Application no: H15/0967/02
Original Applicant: Mr & Mrs Hedger
Honeysuckle Cottage
North Drove
Quadring
Spalding, Lincs, PE11 4QS

Description: Demolition of existing dwelling and detached garage and replace with new dwelling plus retention of existing single storey building for use as annexe.
Location: Honeysuckle Cottage
North Drove
Quadring
Amendment: Proposed new dwelling repositioned 3650 further away from existing single storey building
Letter Sent: 25-MAY-04

**TOWN AND COUNTRY PLANNING ACT 1990
NOTICE OF ACCEPTANCE OF AMENDMENT**

PLANNING AMENDMENT

DRG No. 0017/2/PL/2002¹⁵

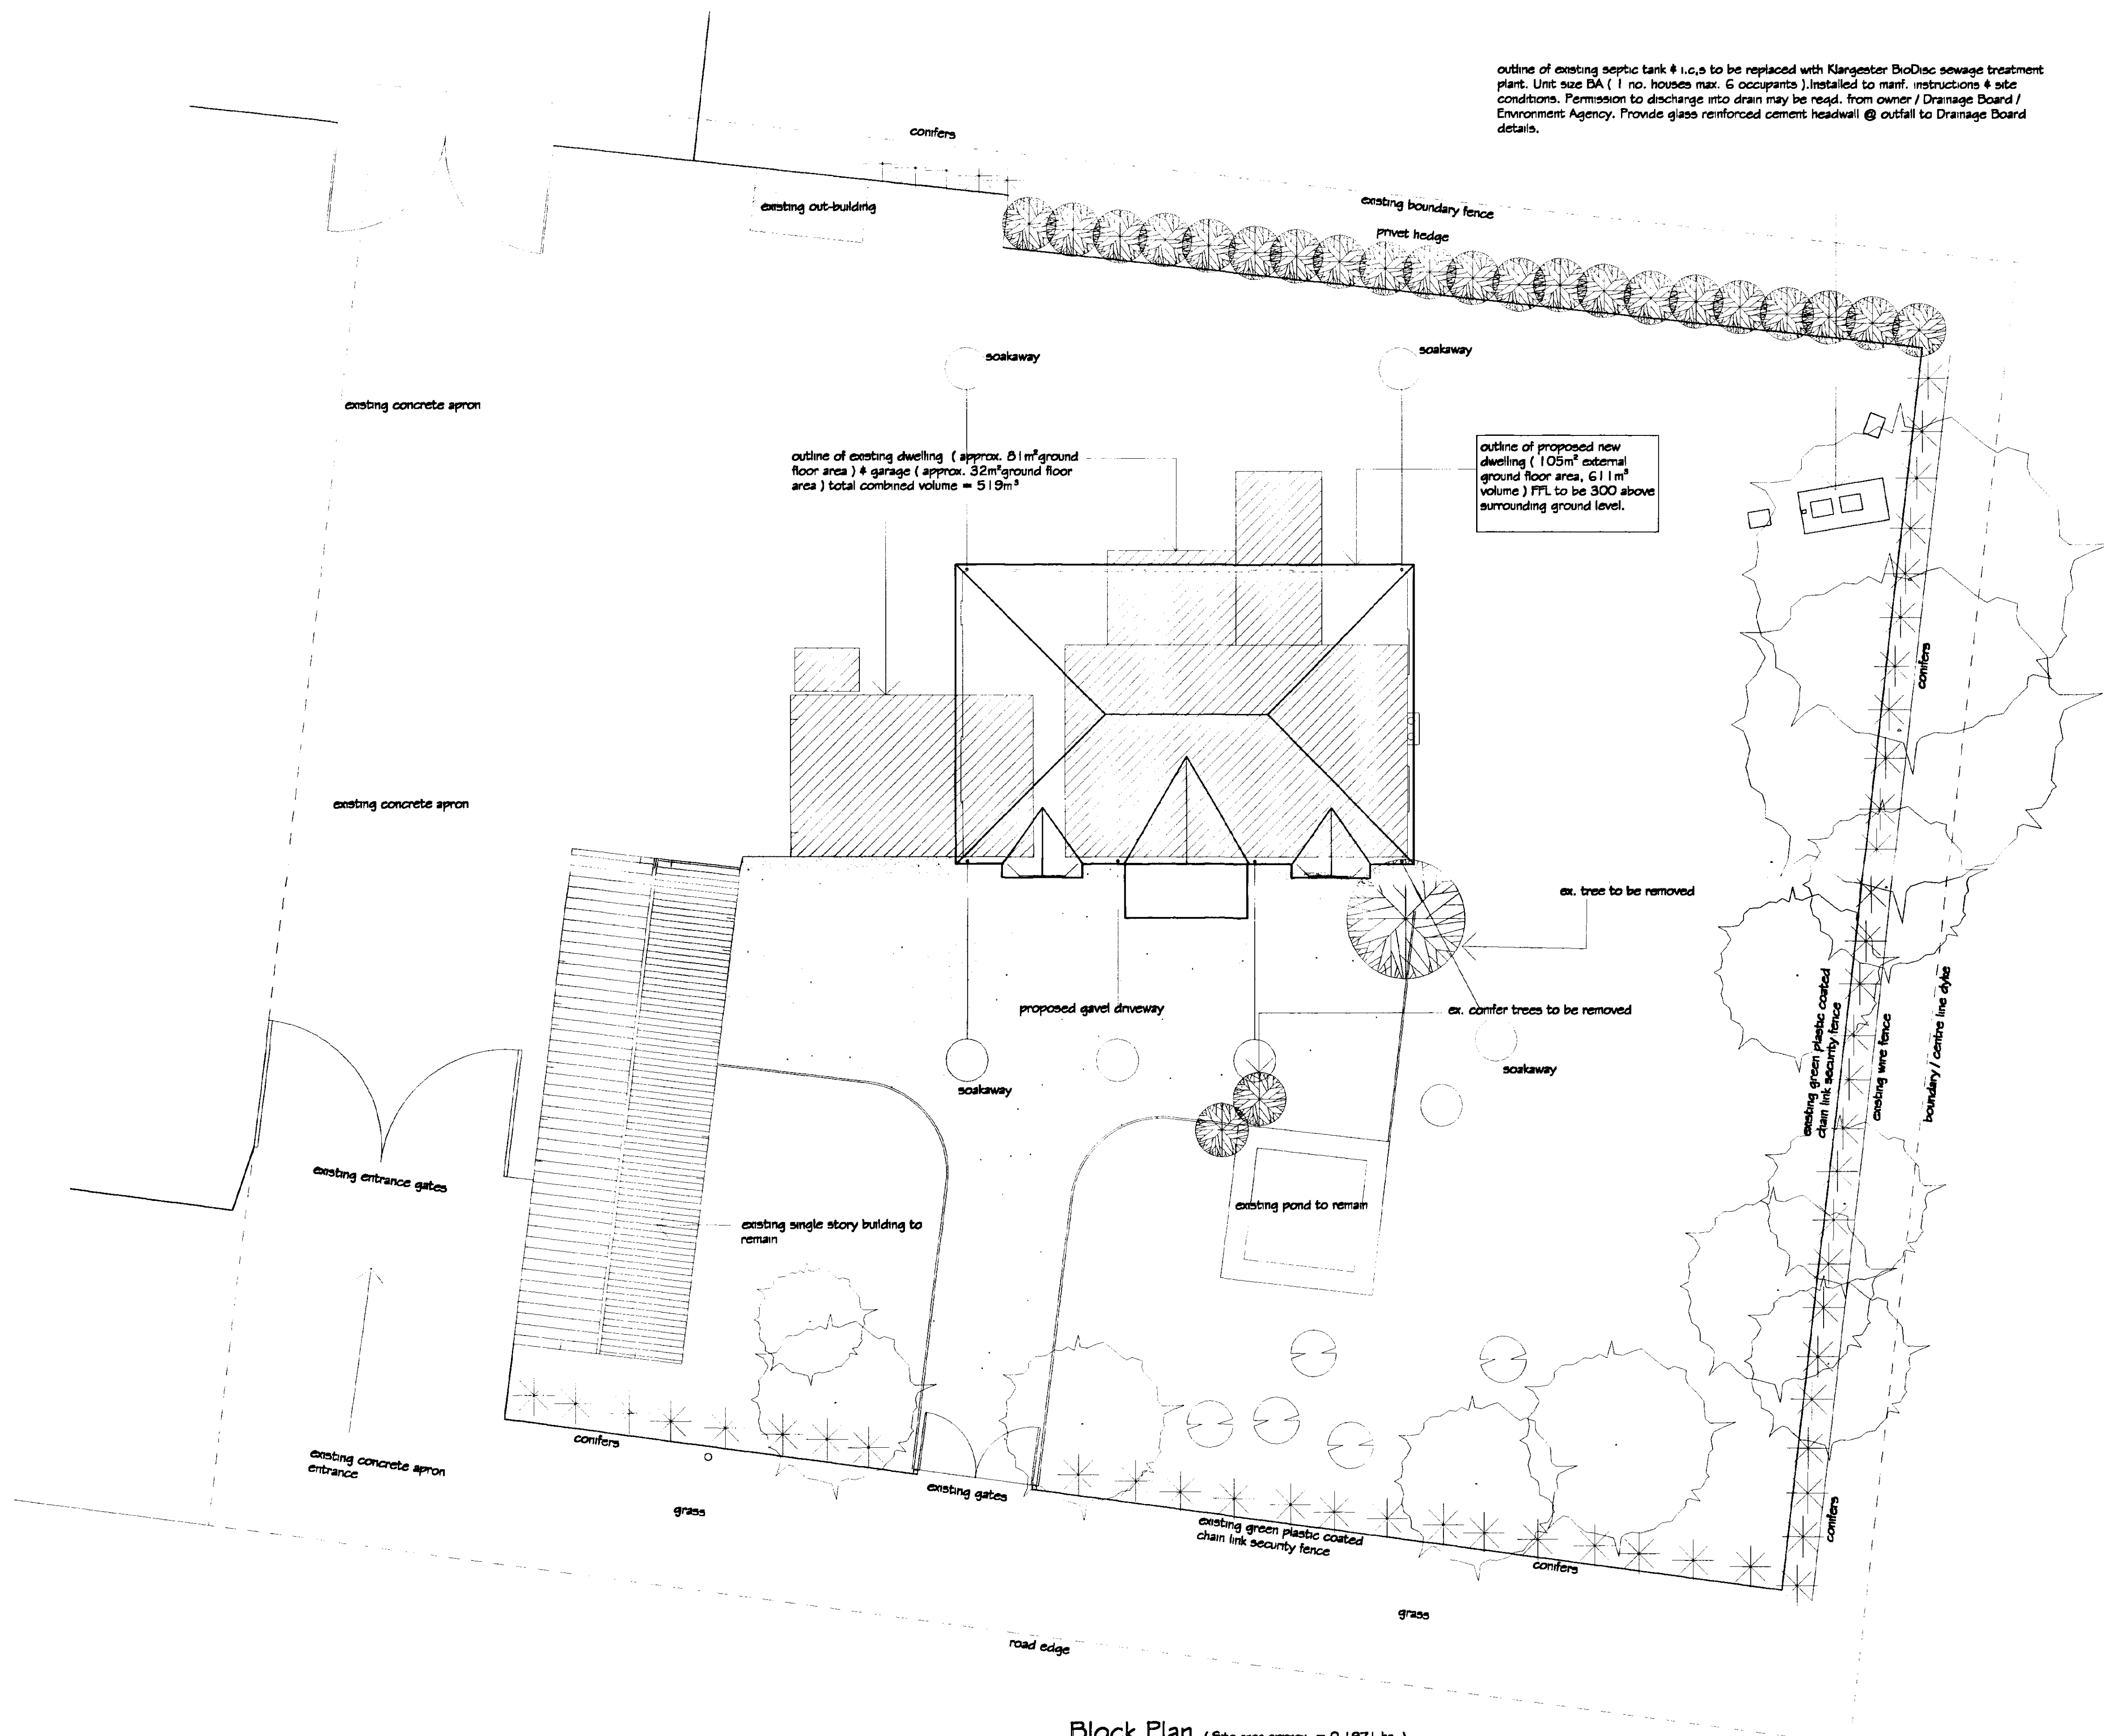
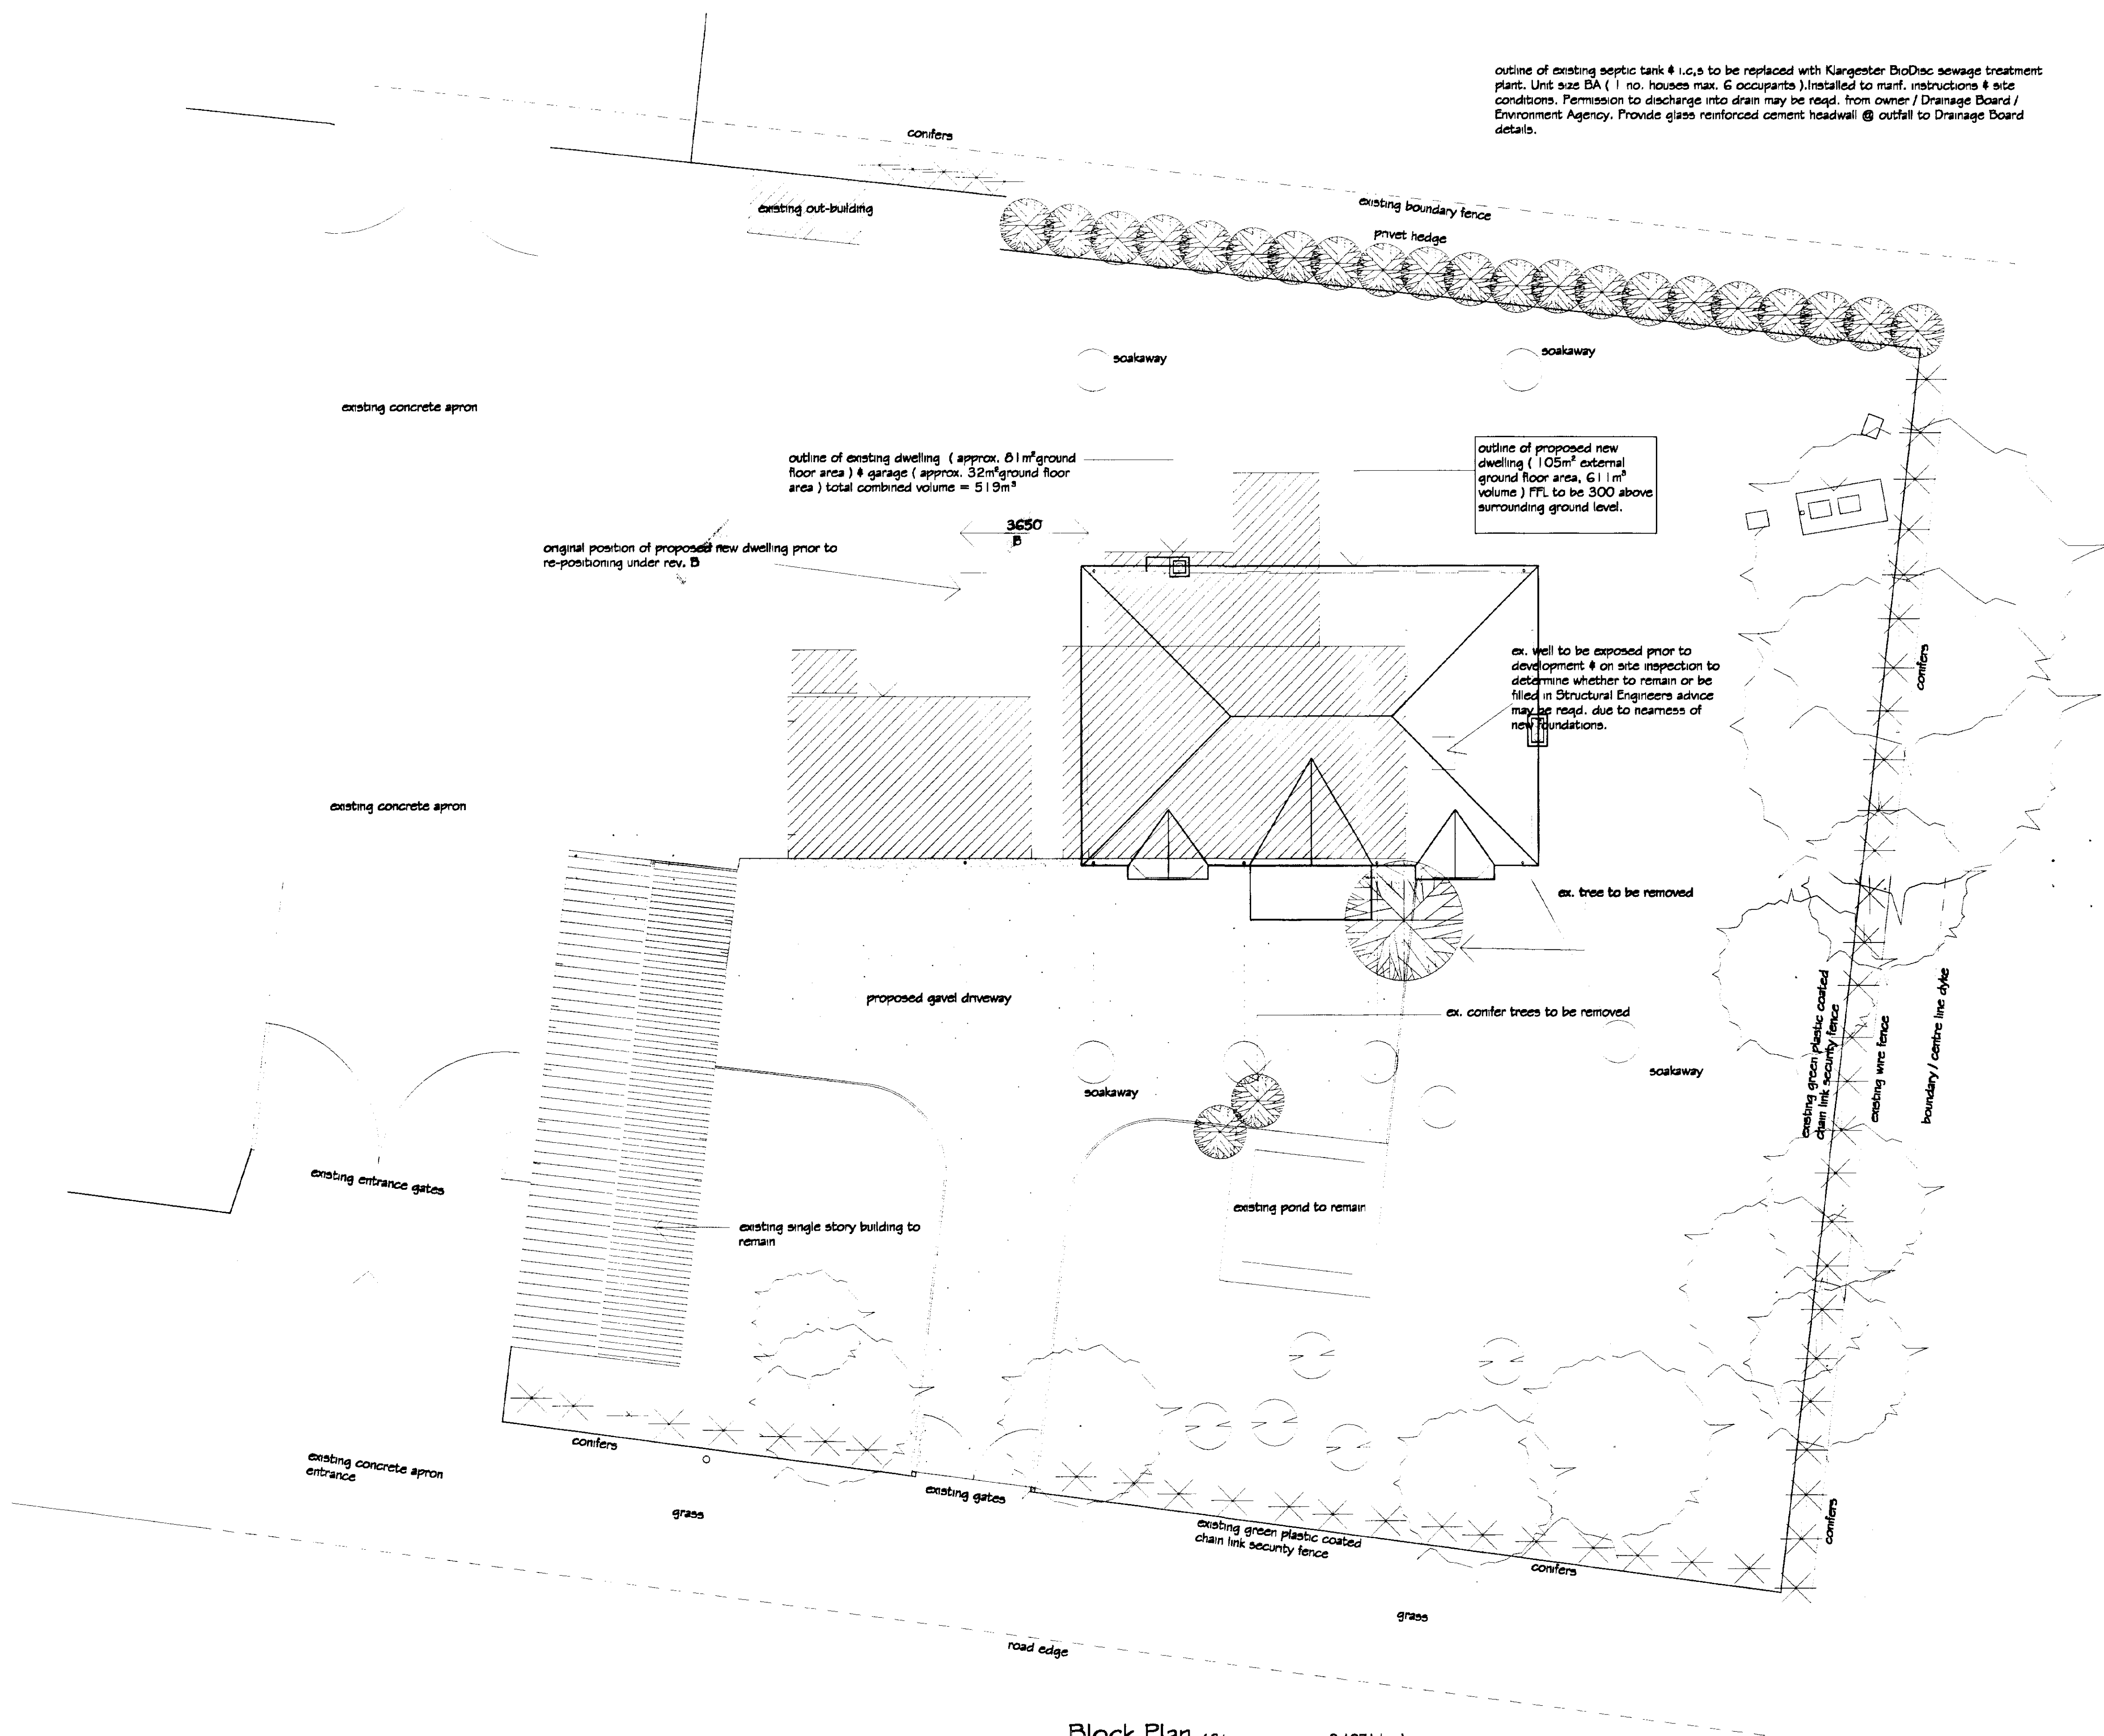
DEMOLITION OF EXISTING DWELLING
to DETACHED GARAGE to REPLACE
WITH NEW DWELLING plus RETENTION
of EXISTING SINGLE STOREY BUILDING
FOR USE AS ANNEXE
RE POSITIONING PROPOSED NEW
DWELLING
